From: [REDACTED]
Sent: 10 October 2019 12:49
To: Planning.Responses <Planning.Responses@arun.gov.uk>
Subject: FW: Planning Consultation on: BN/73/19/PL

APPLICATION NO: BN/73/19/PL
Registered: 11th September 2019
Site Address: Barnham Court Farm Church Lane Barnham PO22 0BP
Grid Reference: 495619 103473
Description of Works: Change of use of The Little Yard to independent dwelling & the stationing of up to 4 No. Shepherd Huts to be used as tourist accommodation. This application affects a Public Right of Way, may affect the setting of a listed building & affects the character & appearance of the Church Lane, Barnham Conservation Area.

Site 3 Long Wood

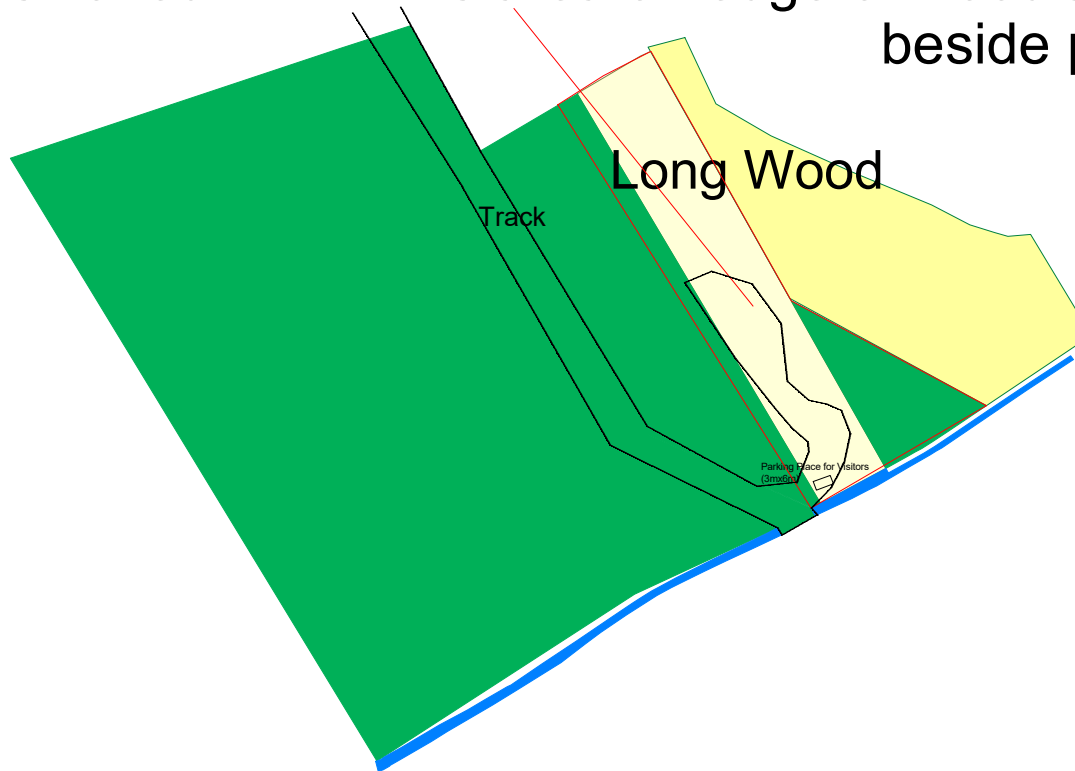
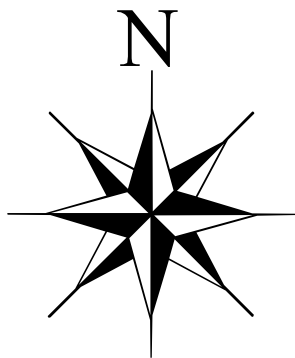
Further to my email below may I add one further comment that I missed and that is that the condition should also state that Site 3 due to it being in such open farmland should not be allowed bbqs.

At a meeting of the Planning & Environment Committee of the Barnham and Eastergate Parish Council the Committee resolved to raise no objection to this application provided a condition was imposed that restricted the number of huts placed on Site 3 to 1 hut at any time. Also there should be no outside lighting provided that would impact on the wildlife in the area.
